11 March 2026

TII26-135157

RE: 10 year permission for Derrynadarragh wind farm comprising of 9 no. wind turbines, onsite 110kV substation, turbine delivery route and a grid connection route located across various townlands in County Kildare, Offaly and Laois

Applicant: Dara Energy Limited

SPA Location	M6 Slip Road / N52 Roundabout	<b>Point of Interest</b> 13	<b>Drawing No.</b> SK10A	<b>Notes:</b> 1. All mitigation is subject to confirmation through a test run. 2. This is not a construction drawing and is intended for illustration purposes only.			Revision
Wheel SPA	Body SPA						1

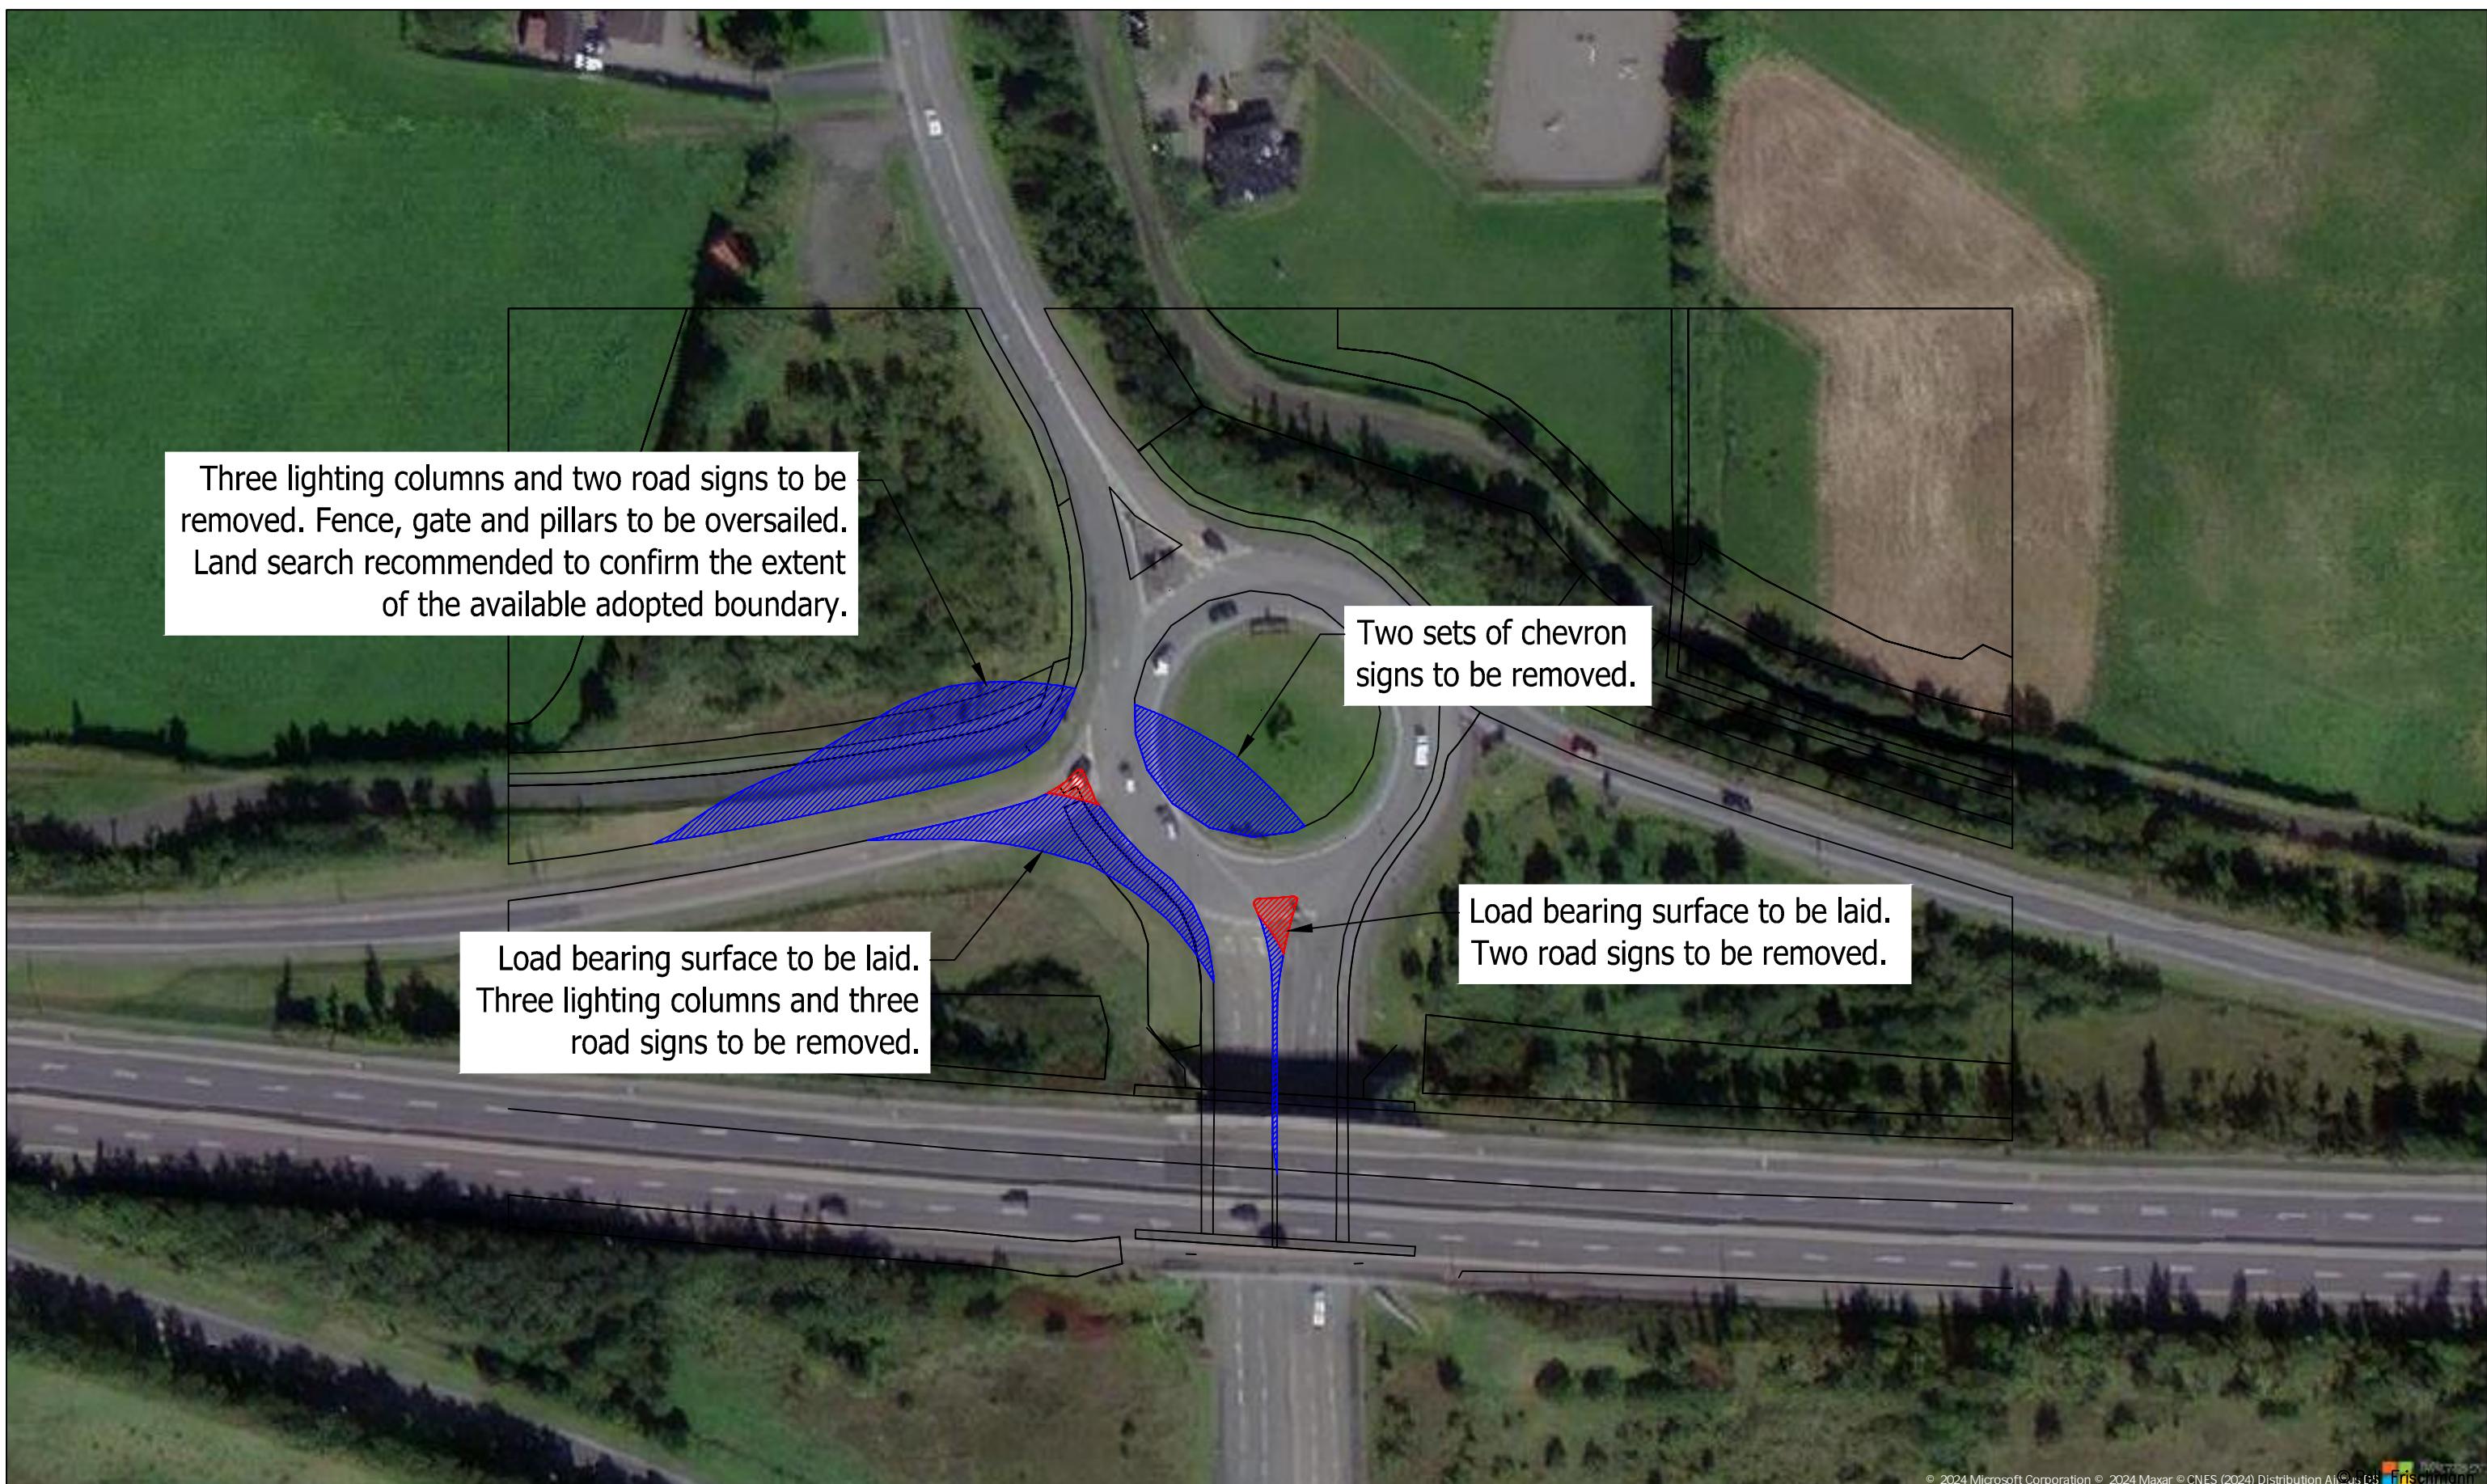
including abnormal load permitting and temporary accommodation works to identified locations, including on the national road network (“*node reference 13*” M6 Slip Road / N52 Roundabout).

- iii. Any damage caused to the pavement of the existing national road due to the turning movement of abnormal ‘length’ loads (e.g. tearing of the surface course) shall be rectified in accordance with TII Pavement Standards and details in this regard shall be agreed with the Road Authority prior to the commencement of any development on site.
